**Consultation Response from KC,  
Trees**

**2024/93605 Land at, Main Avenue, Cowlersley, Huddersfield, HD4 5US**

**Erection of 57 dwellings with access from new through road connecting Main Avenue and Windsor Road, and associated works, including engineering and landscaping**

**Date Responded: 21/01/2025**

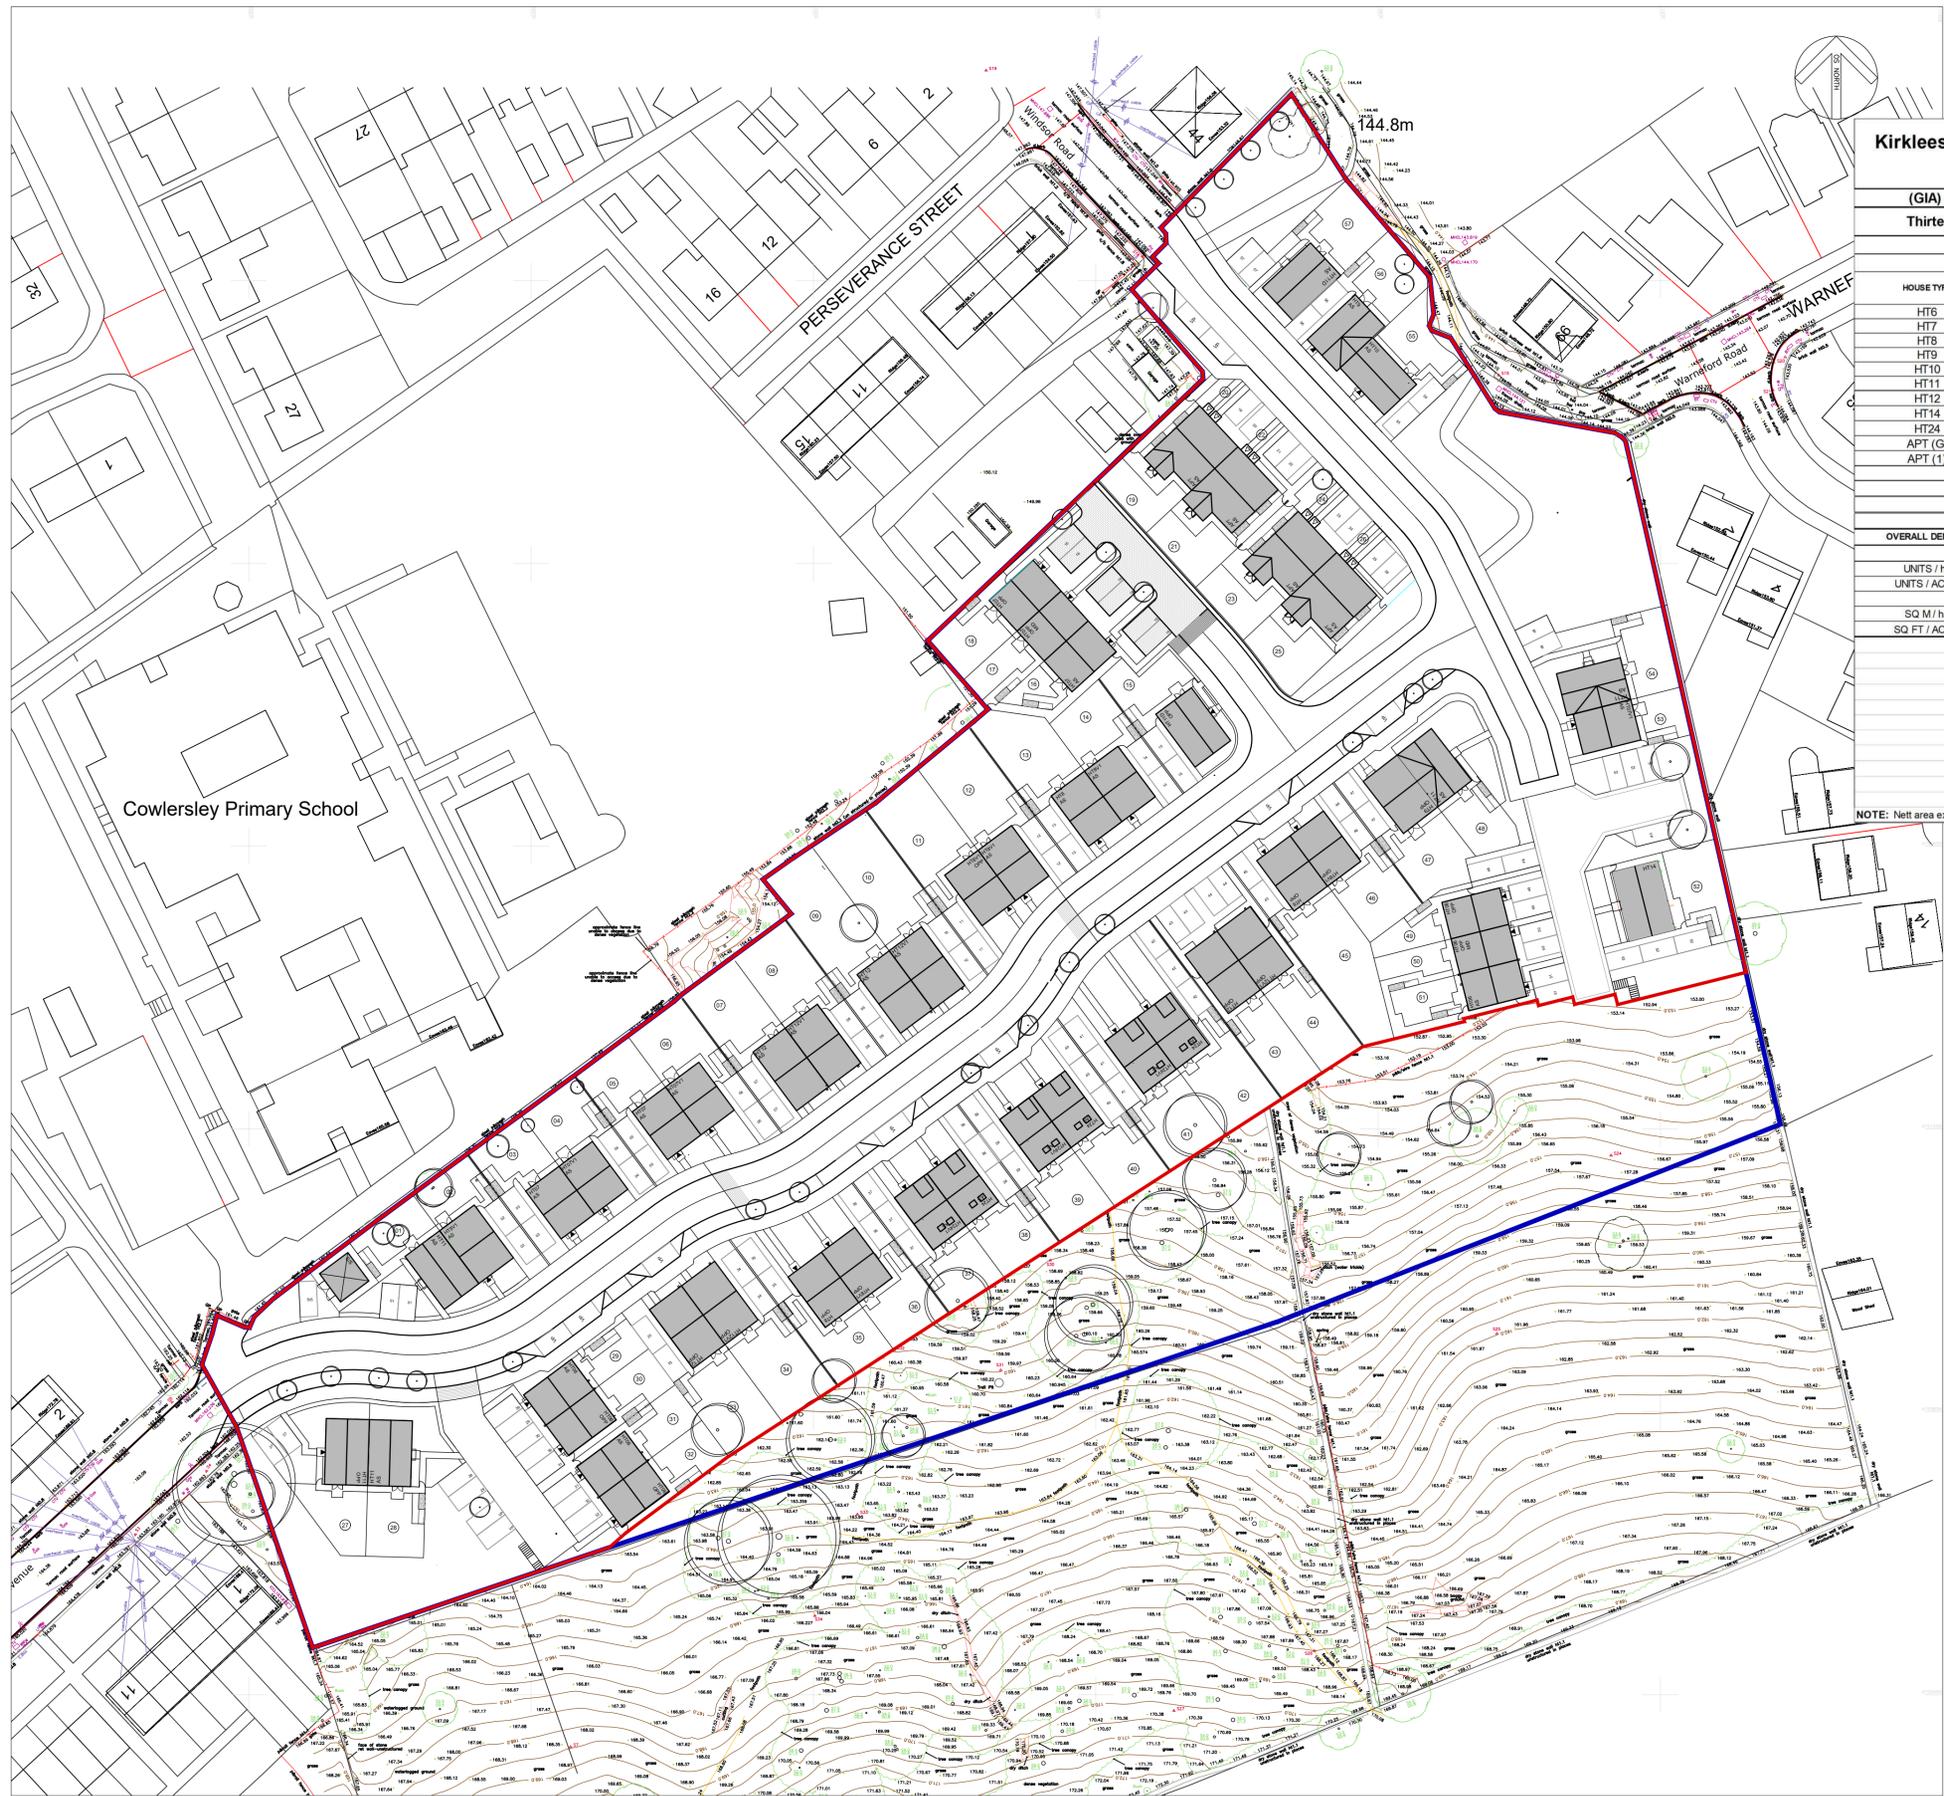
The design of the development doesn't appear to have taken any of the existing trees into consideration when finalising the layout. There appears to be an opportunity to retain a large sway of category B trees by incorporating them into a green open space where plots 35 to 41 are currently suggested.

**KEY - POS TYPOLOGIES**

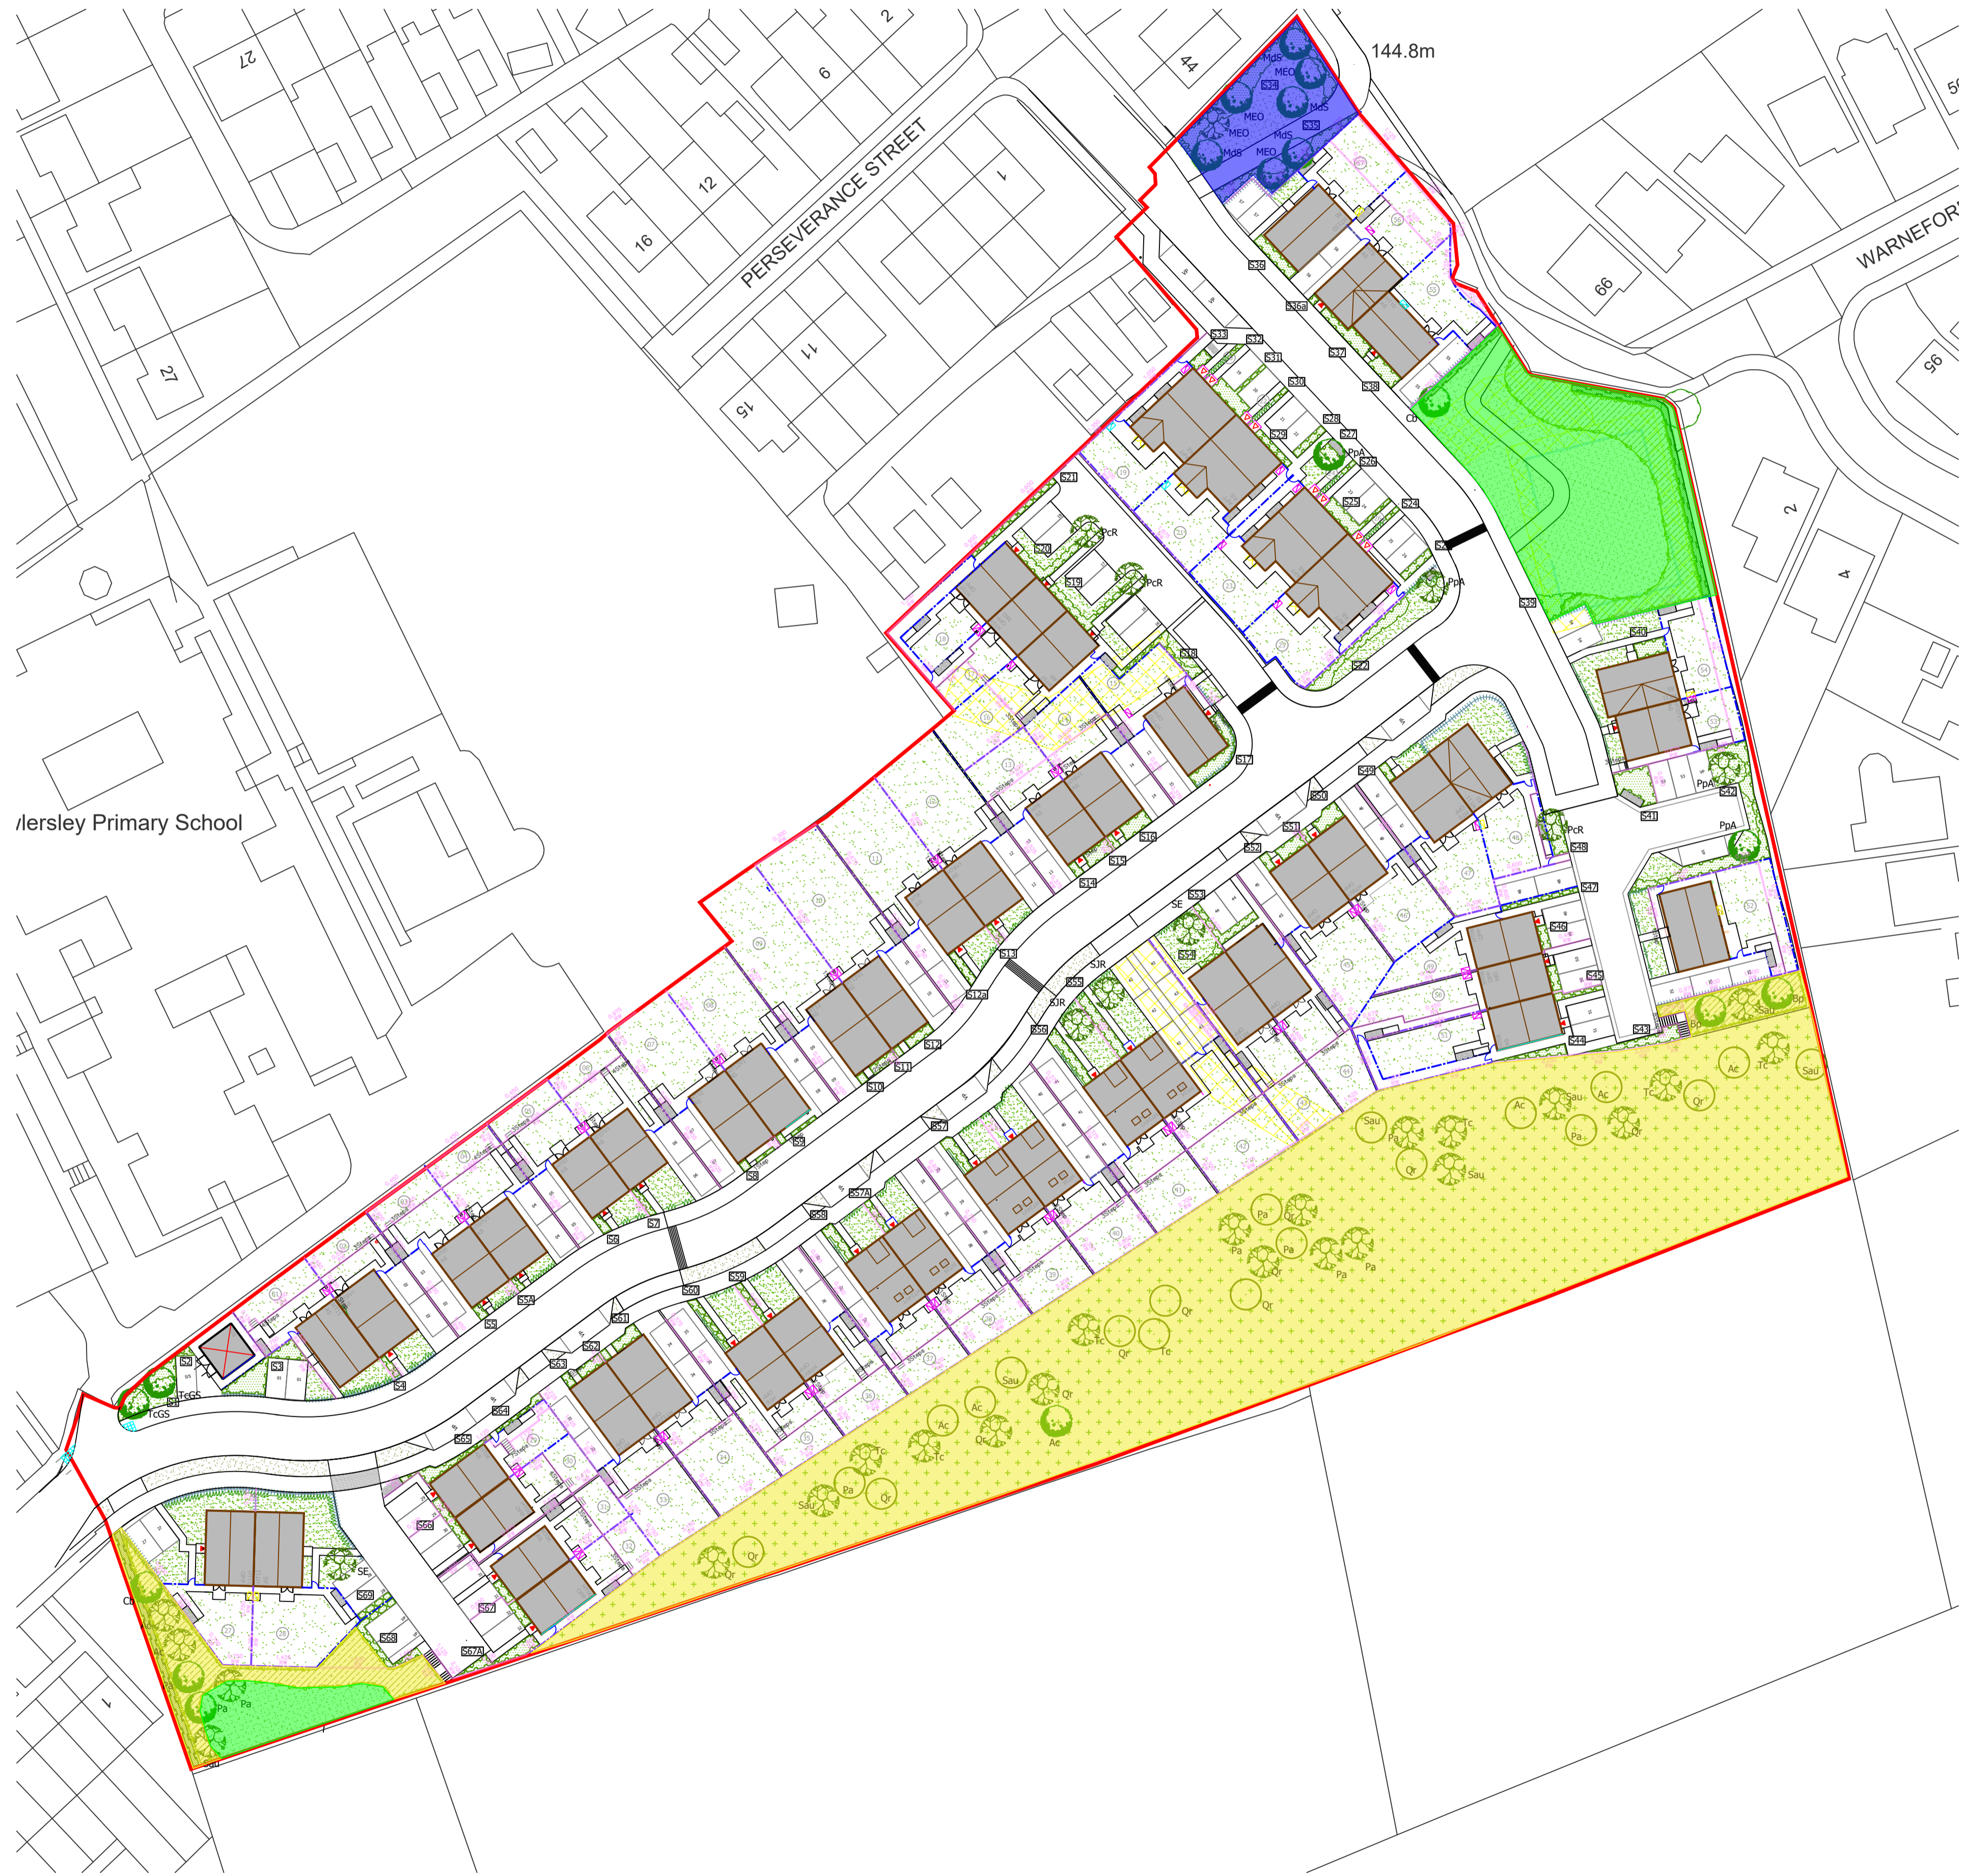
The submitted landscape master plan currently doesn't mitigate the loss of 34 individual trees and 12 groups of trees that are currently suggested for removal. A lot of the trees down for removal have large growth potential such as the Oaks and all proposed tree planting is of species with lesser potential.

There is potential for a small woodland to be planted along the southern boundary which would not only improve the current sites visual amenity but also the biodiversity within the area. This would sufficiently mitigate the loss of the existing trees and work with the current layout
